# Engineers Comments Regarding Surface Water Drainage

<b>Application Reference:</b>	LU/193/25/PL	<b>Reviewer Reference:</b>	ADC/EXT2/D2134/86
<b>Planning Officer:</b>	Harry Chalk	<b>Date of Review:</b>	12.12.2025
<b>Site Name:</b>	Court Wick Park Courtwick Lane Littlehampton BN17 7PD		
<b>Application Description:</b>	Proposed residential development for 4 houses and associated landscaping. This application may affect the setting of a Listed Building and is in CIL Zone 2 (CIL liable as new dwellings).		
<b>Assessment Number:</b>	1 of 2

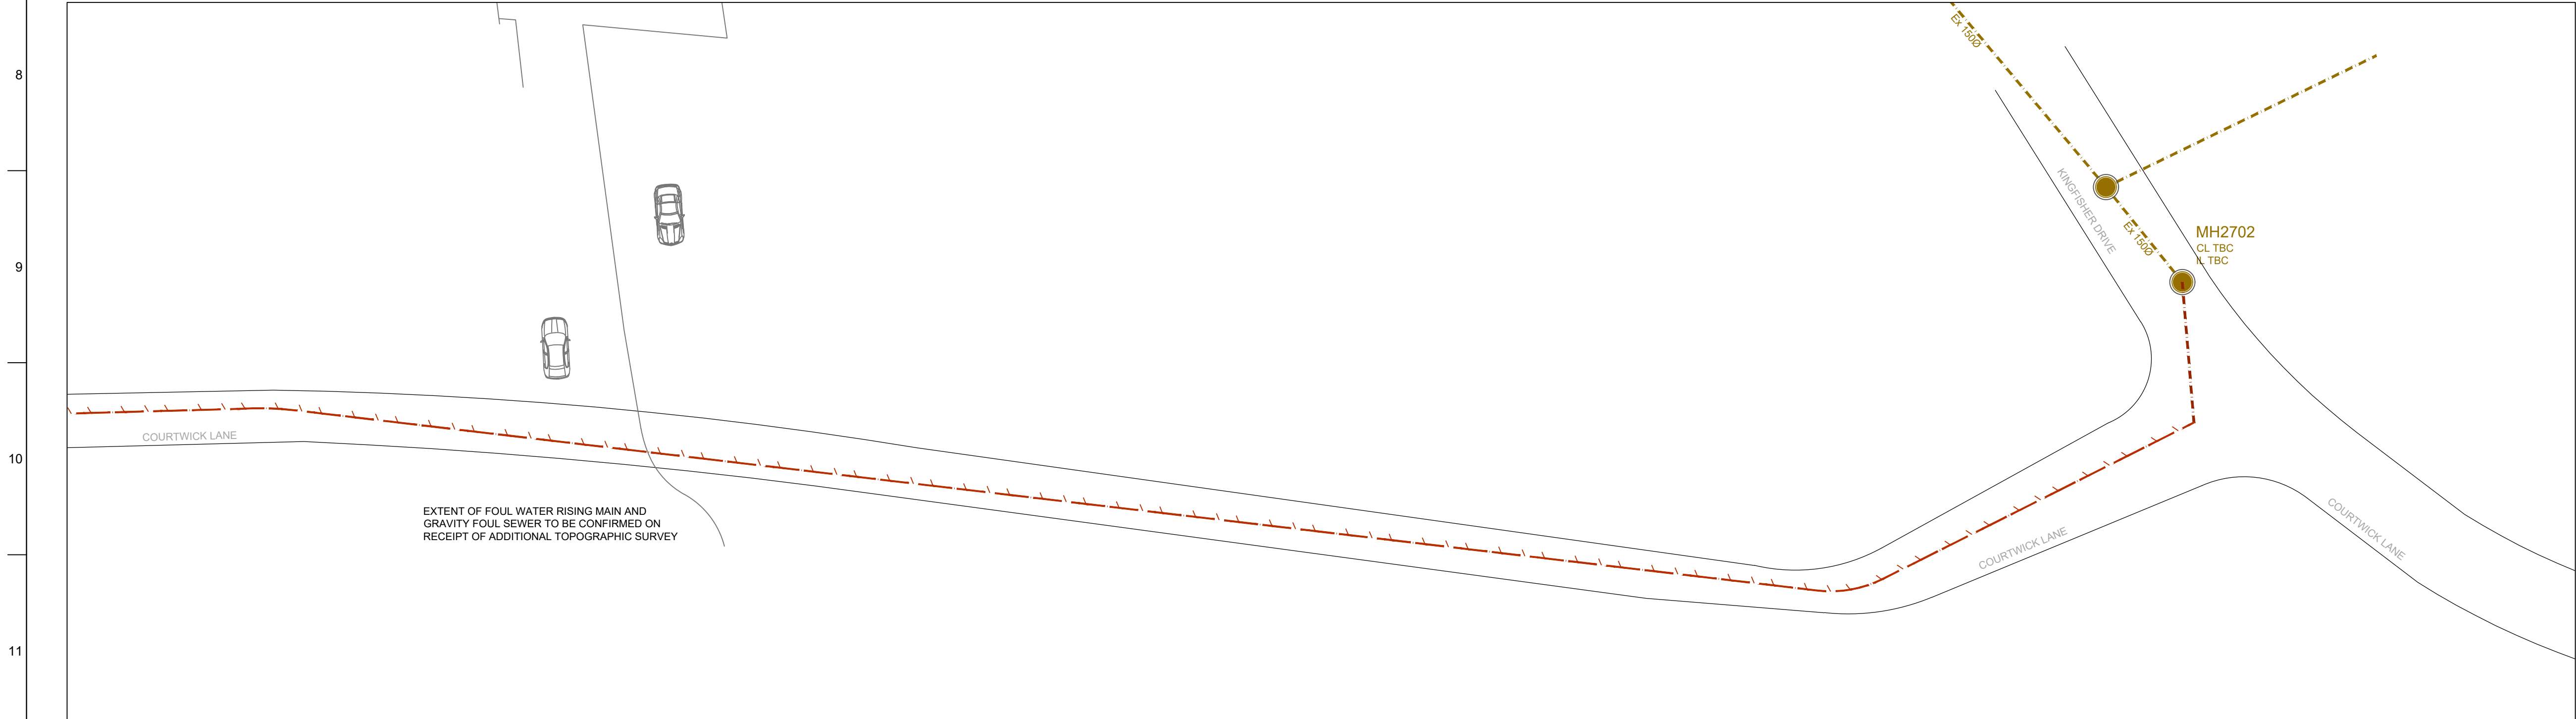
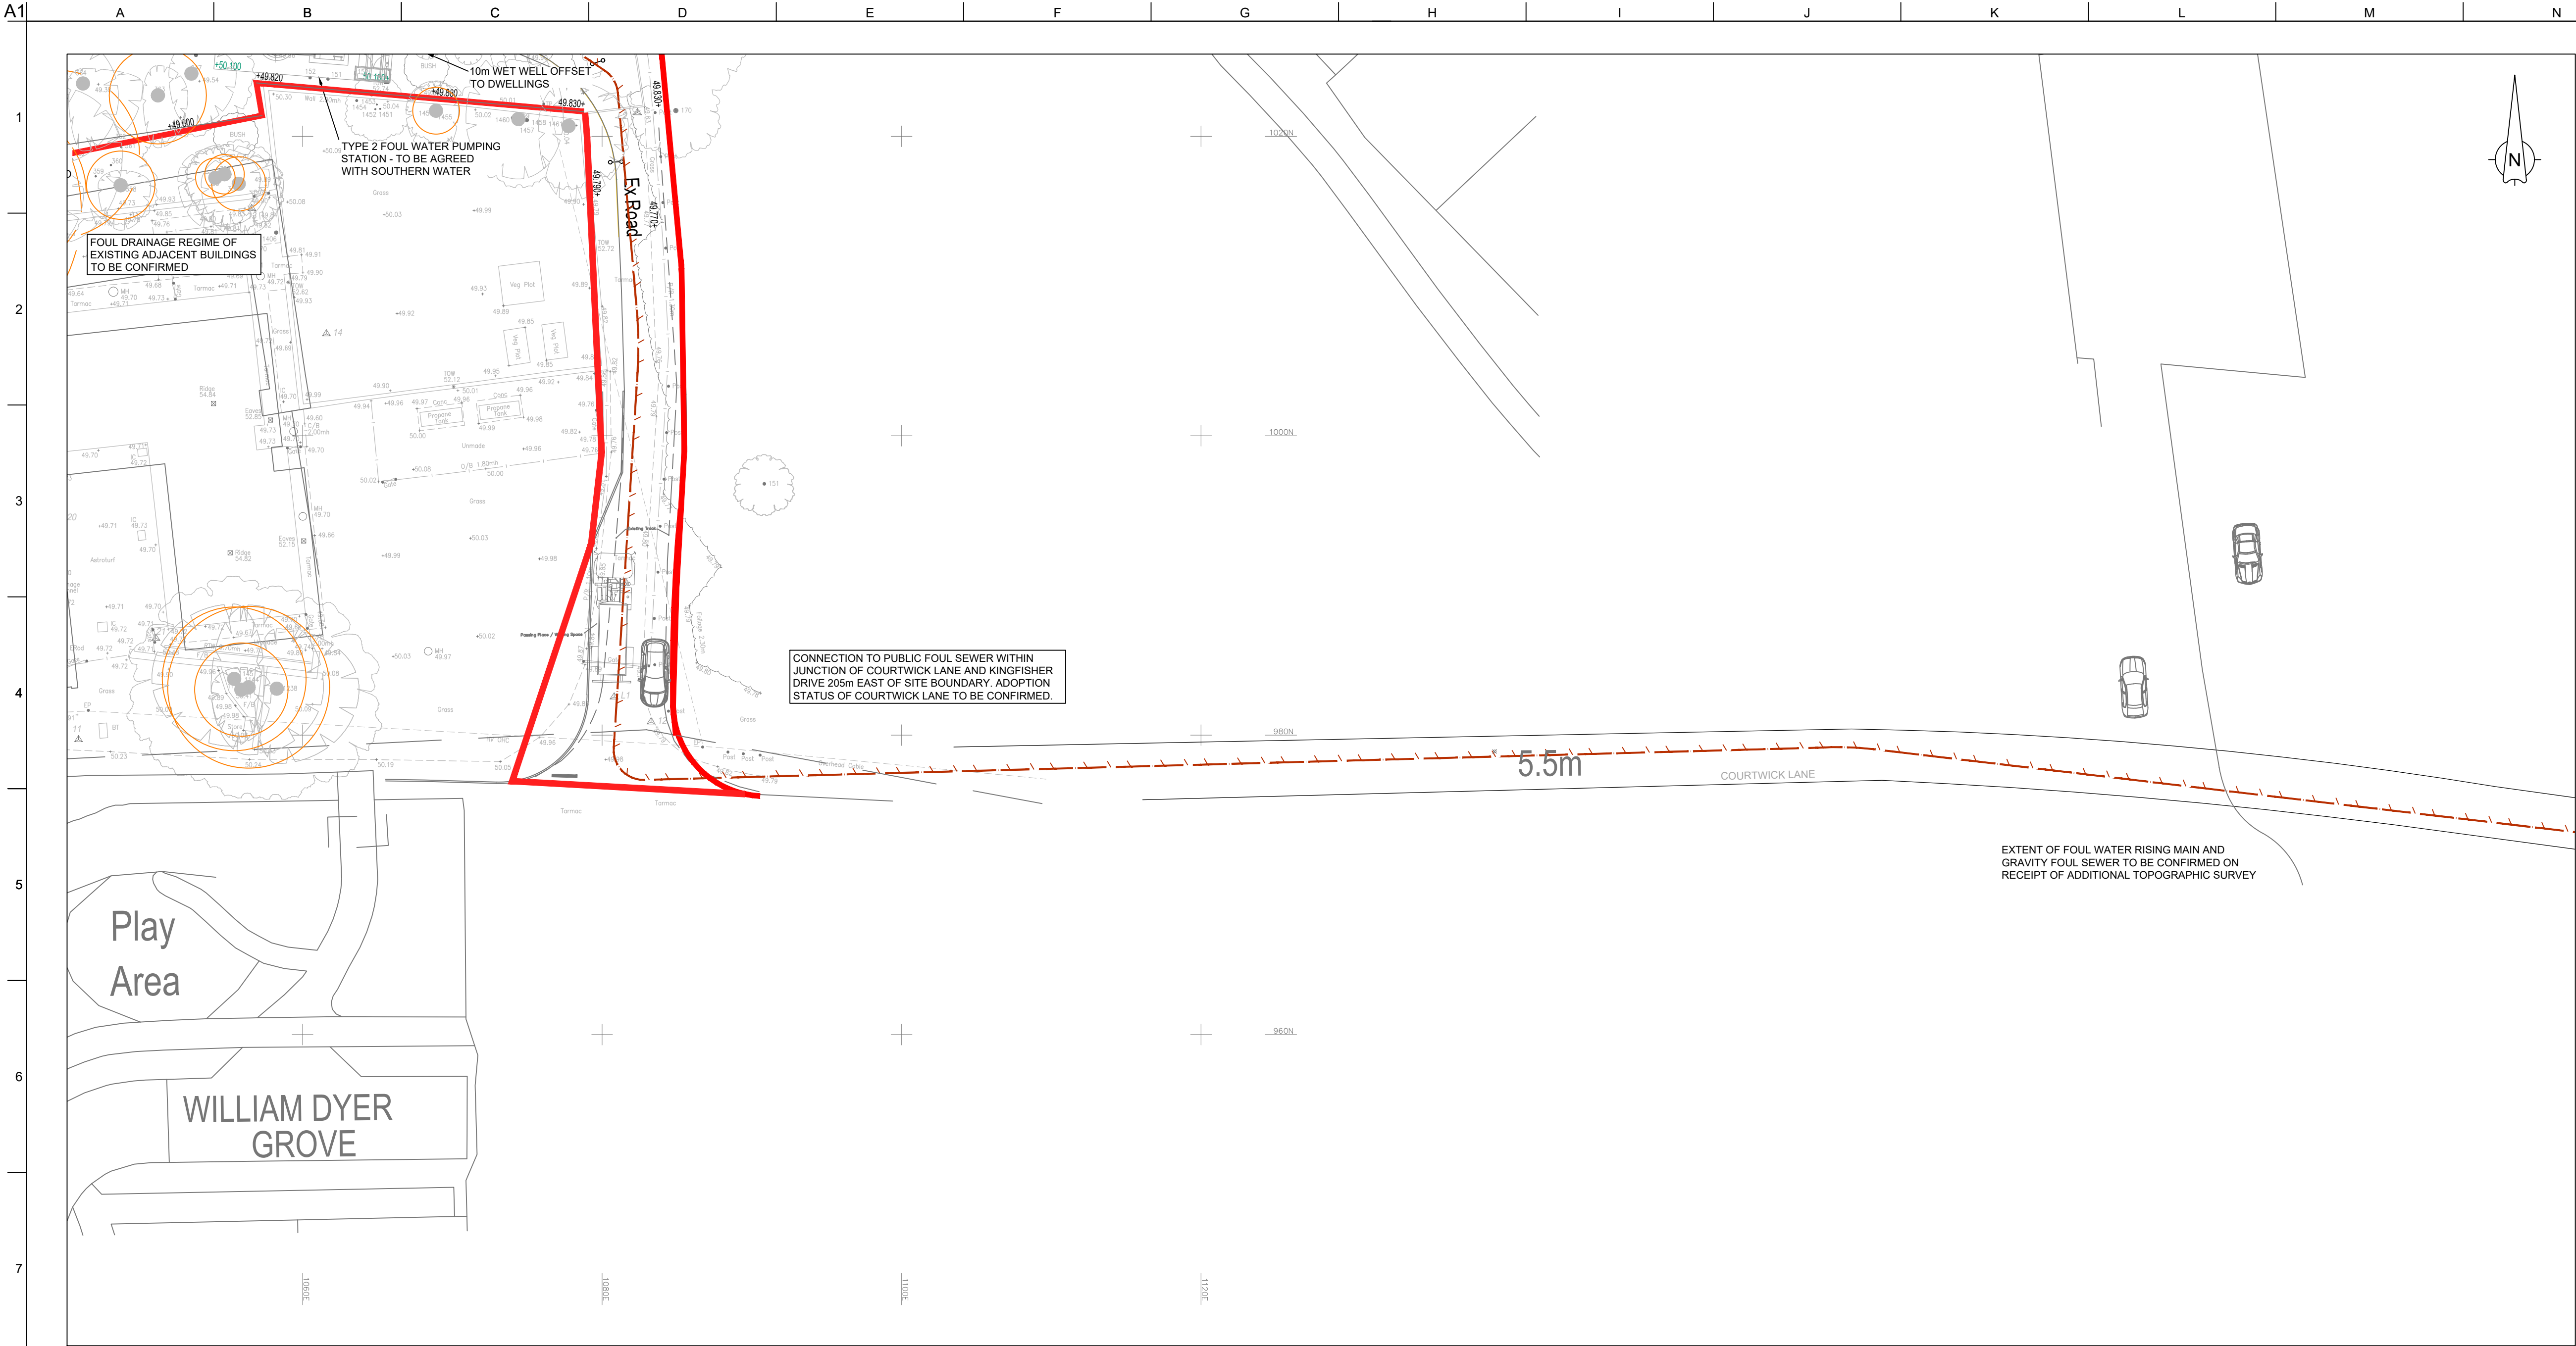
- 0.8. The use of permeable pavements is highlighted on the drainage GA key, however is not shown on the plan. The extent, specification and calculations must be provided.

- 3.1. The drainage design does not comply where the design is for a 10yr return period. This must cater for the 100yr return period, plus climate change and urban creep factors. It must also demonstrate the 50% half drain down time lies within 24hrs for the 30yr event.
- 3.2. The design drawings must highlight the extents for the risk of surface water flooding where this may impact on the current location of dwellings. Whilst some mitigation of ensuring a 300mm elevation is proposed, pre-development and post completion exceedance routing must be evidenced to ensure the proposals are suitable for the lifetime of the development. This must include evidence of the risk of surface water flooding catchment where this may convey run-off on/off the site, and consider flood depths and drain down durations.
